# **CW PIPELINES - PERMANENT EASEMENT REPORT**

**KILLINGHOLME POWER STATION**

**JULY 2012**

Drawing file: published-documents / TR030001-003455-Able NMC - Tab 3(1) - Substitute Plan - AME - 02006 C Indicative Masterplan.pdf

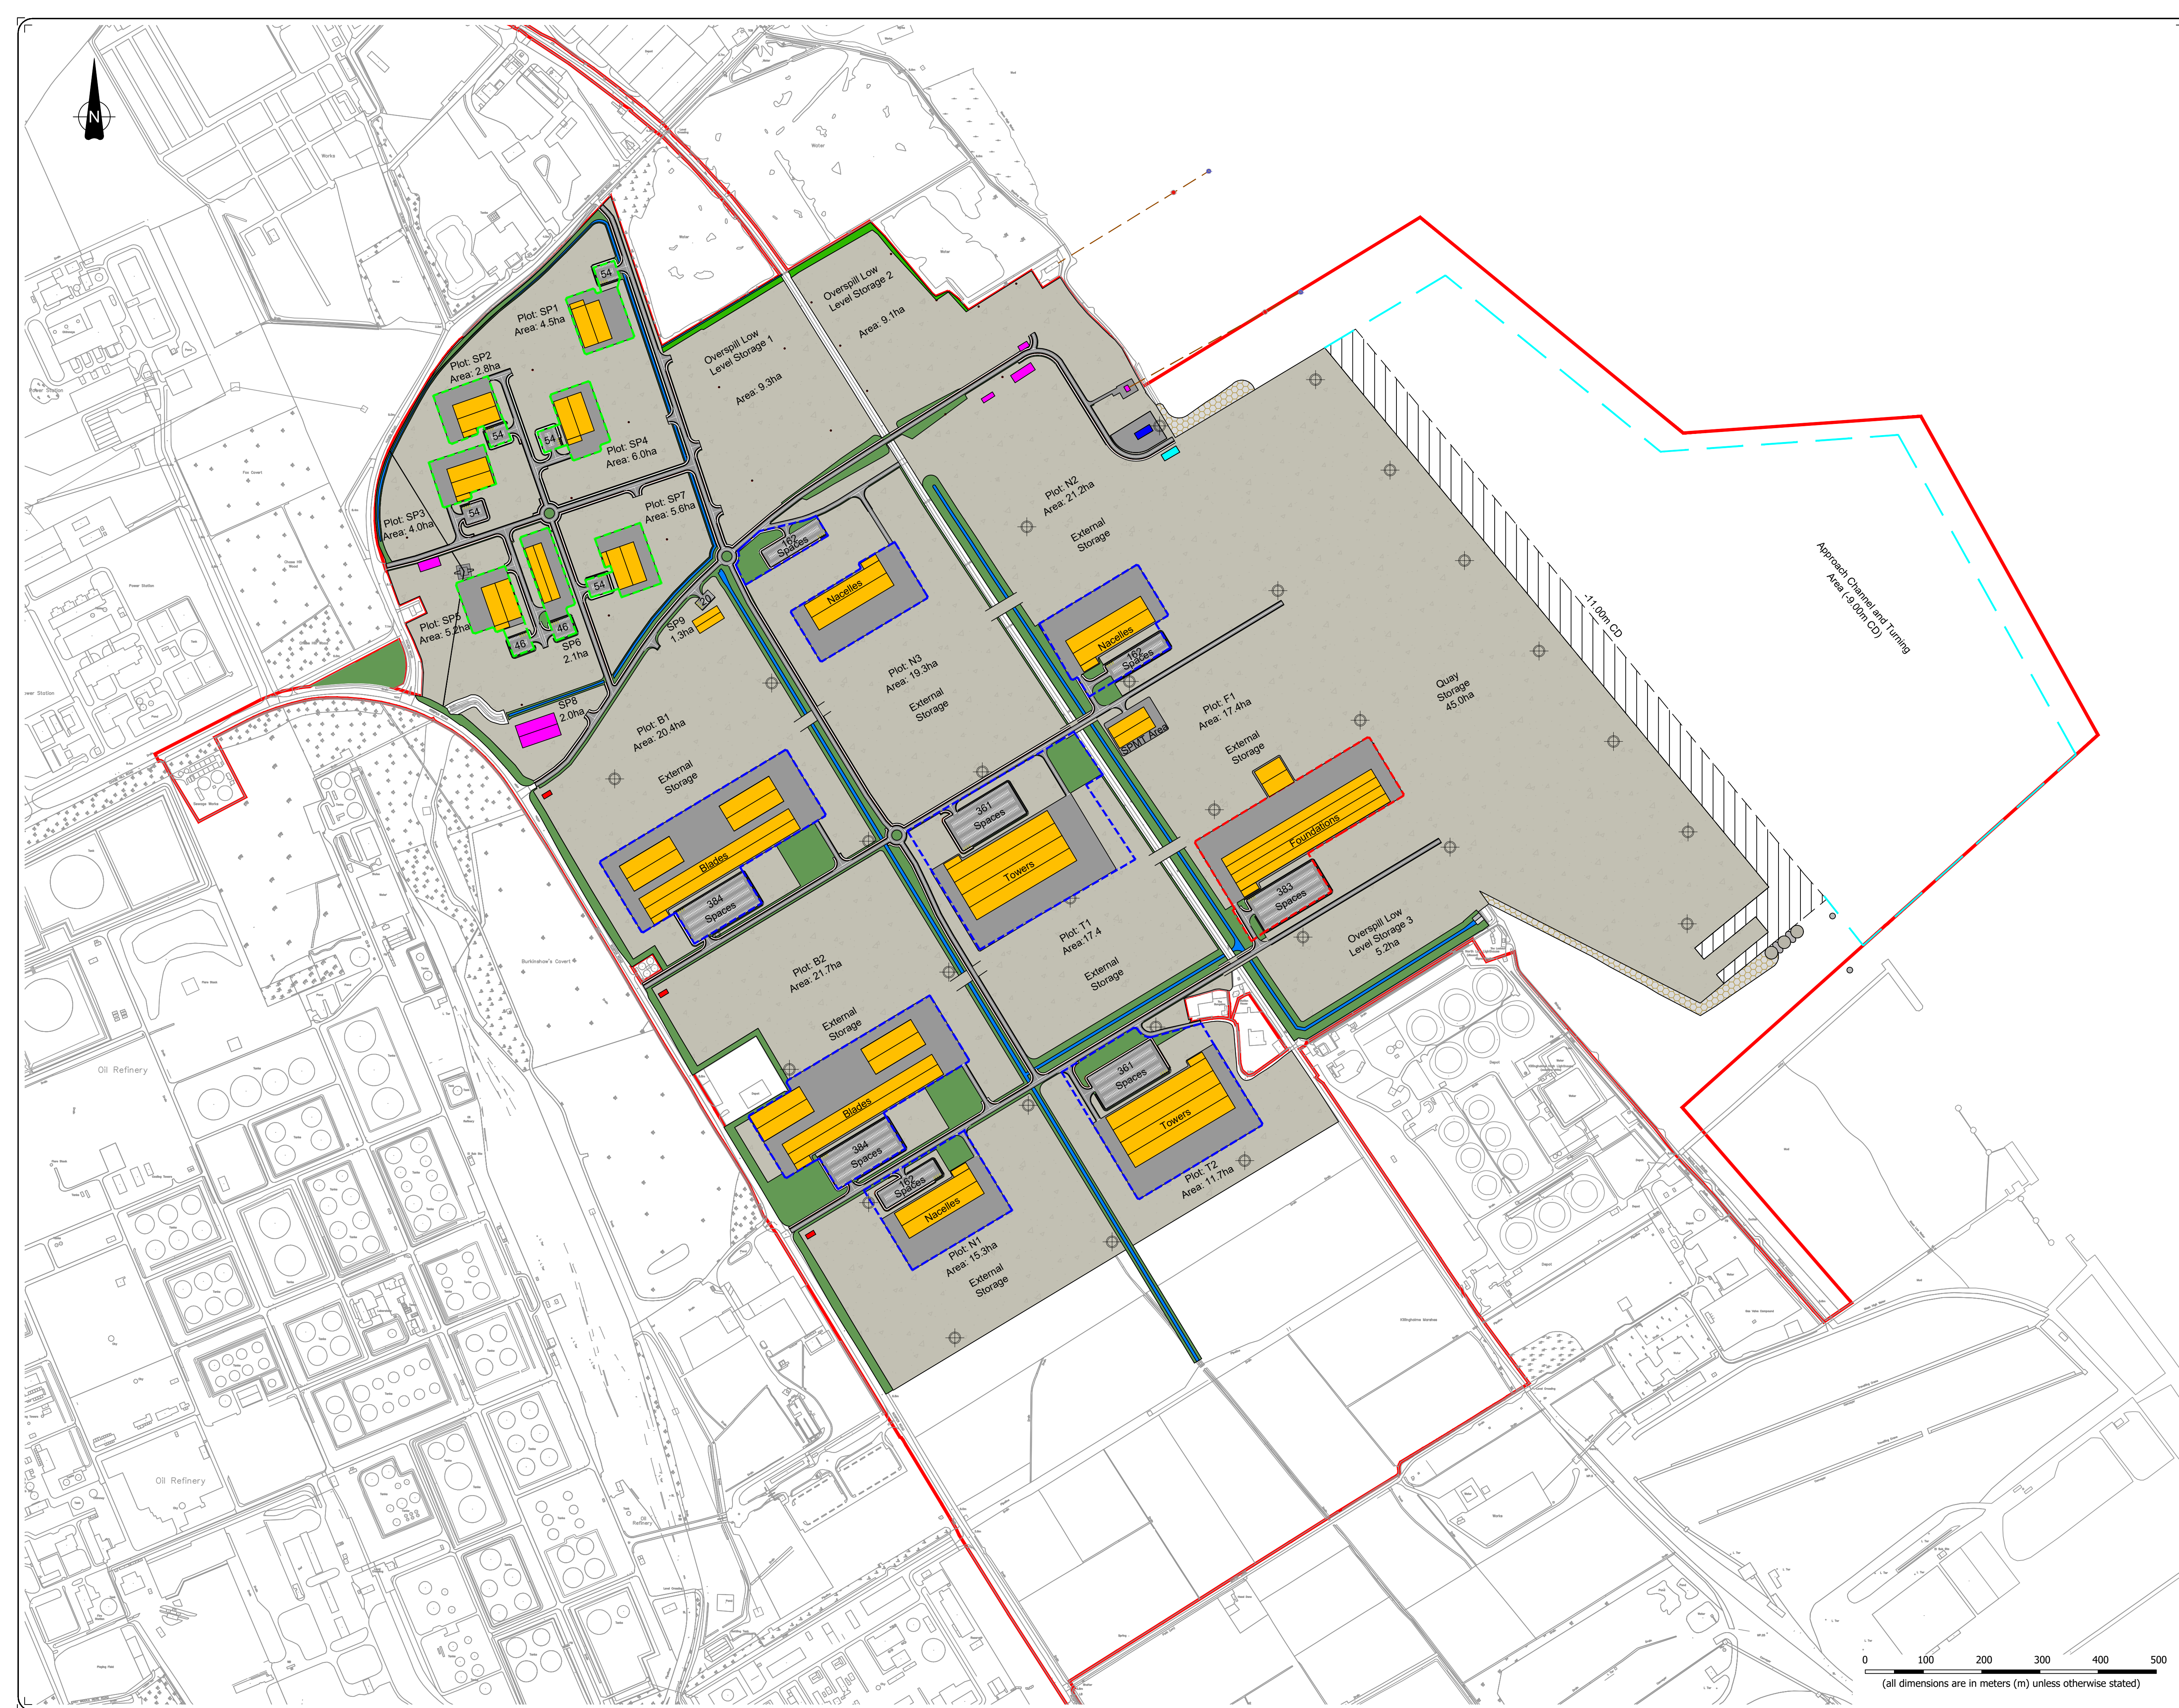
A Developer wishes to build on the land to the east of the Power Station and in doing so requests the 'permanent easement' to be reduced to 12.5m.

CSL would confirm that the proposed 12.5m easement corridor is insufficient for any future intrusive works on the deeper large bore pipelines.

Based on the above and considering the Health and Safety requirements for any future works, CSL would recommend a minimum easement of **31.7m**. This is above normal easement agreements for most pipelines, however the presence of two pipelines in close proximity as well as the cables results in a larger easement being required.
